9 July 2008

re: MP 08_0085 Goodman Fielder Production Facility

Reference is made to your email correspondence dated 7 July 2008 requesting comments in reply to the submissions to the exhibition of the Environmental Assessment. We reply as follows.

Project
 TEMPLAR ROAD - ERSKINE PARK
 SITE E - SITE PLAN

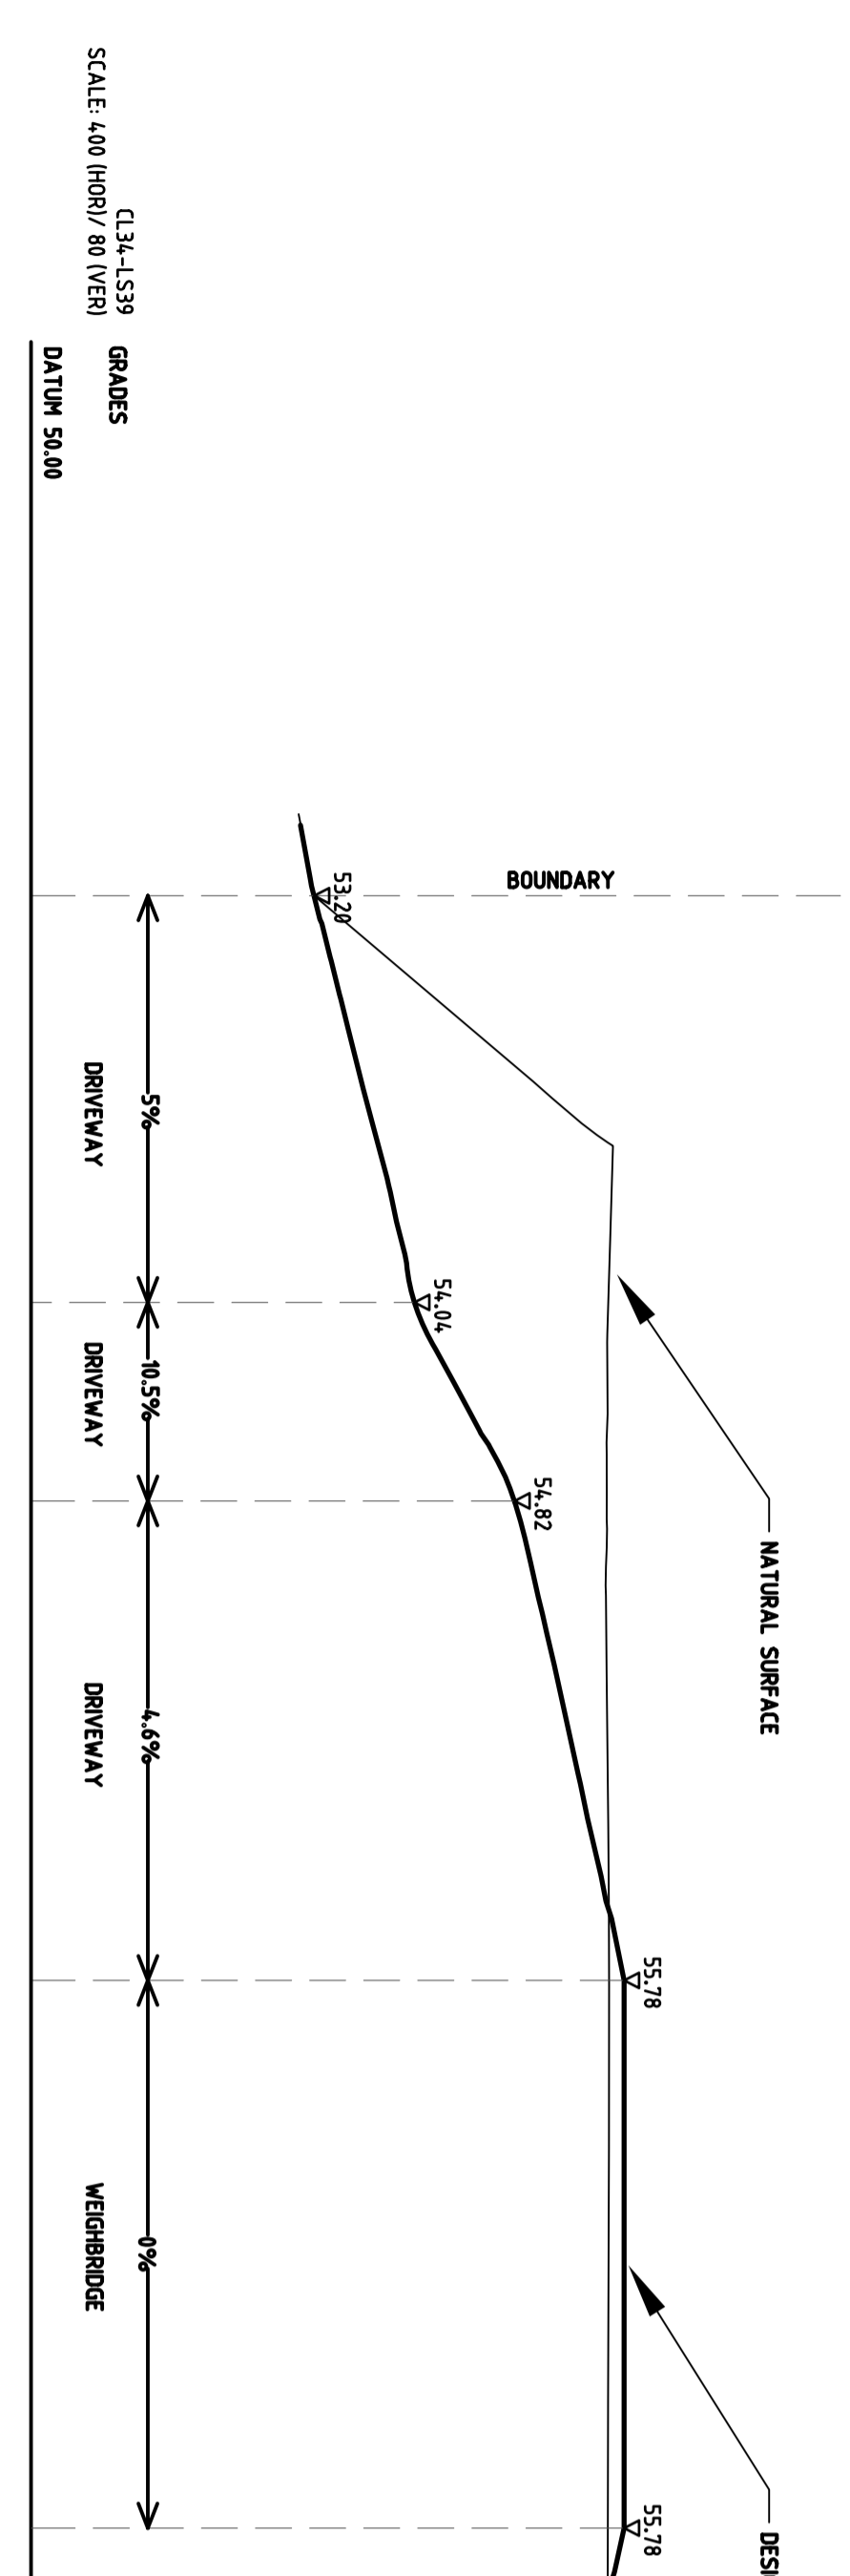
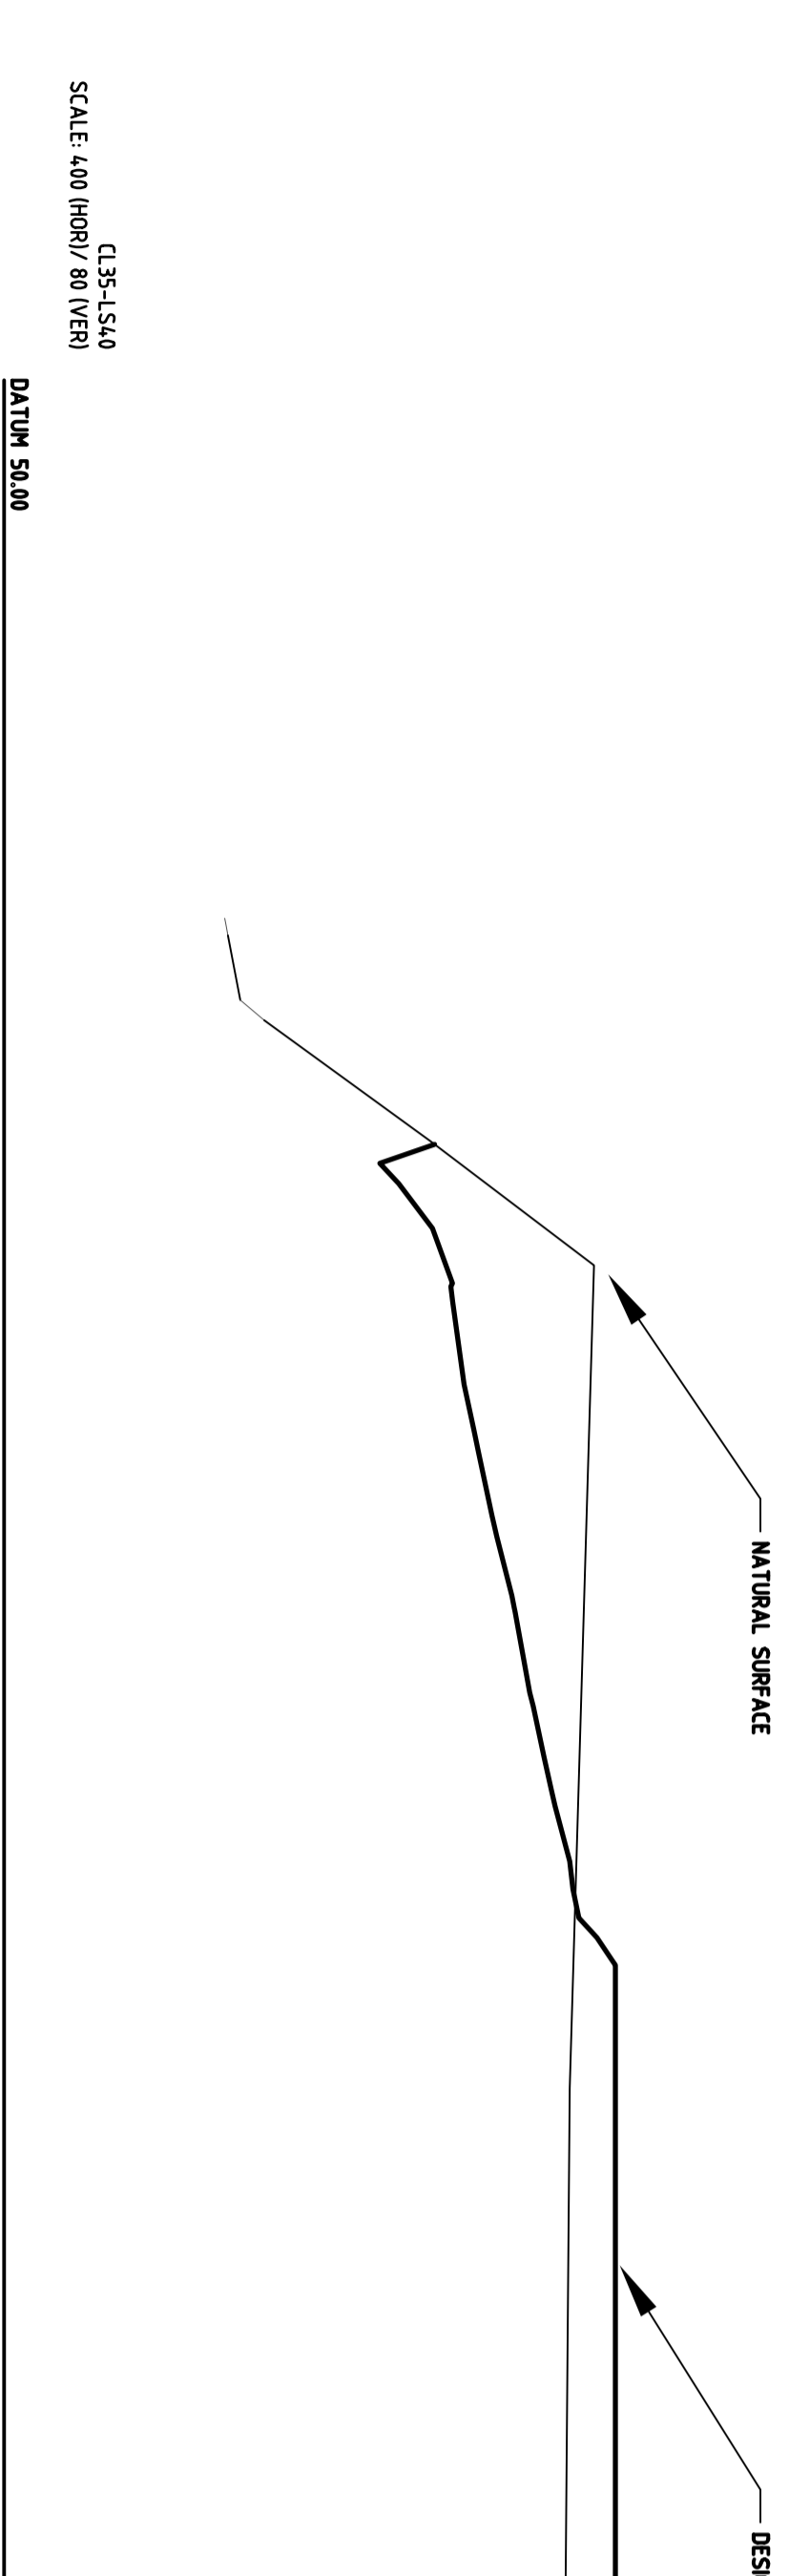
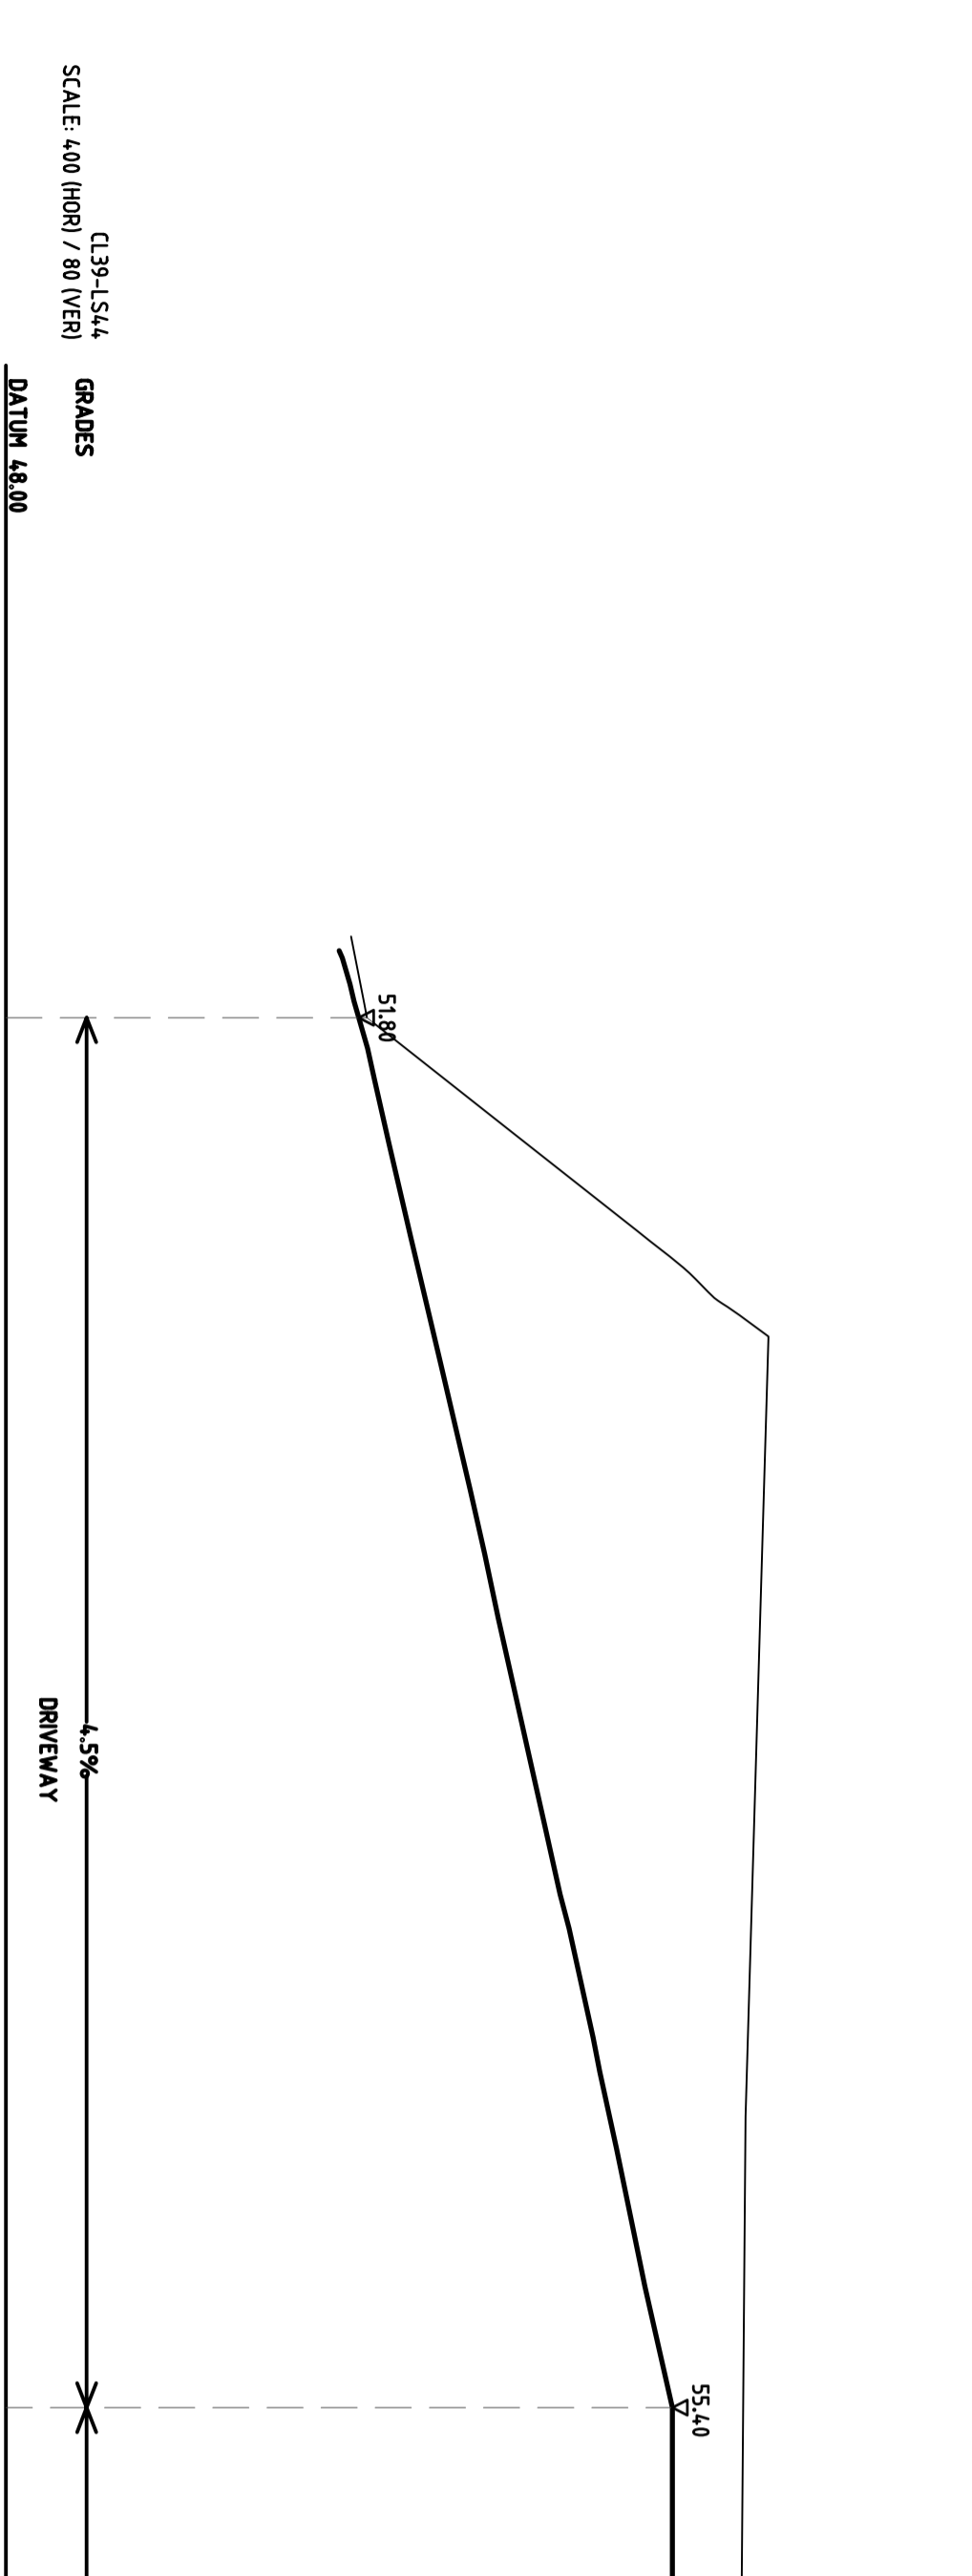
2. Proposed Drainage System

The stormwater drawings have been amended to ensure that the infrastructure for this development is not within the public street (Attachment 5). Consequently the private stormwater line will not be within a public road reserve. Advice received from Buckton Lysenko is that the street drainage system does not have the capacity to accommodate the planned stormwater discharge from the site. Consequently additional infrastructure has been provided and is not located within a public road reserve.
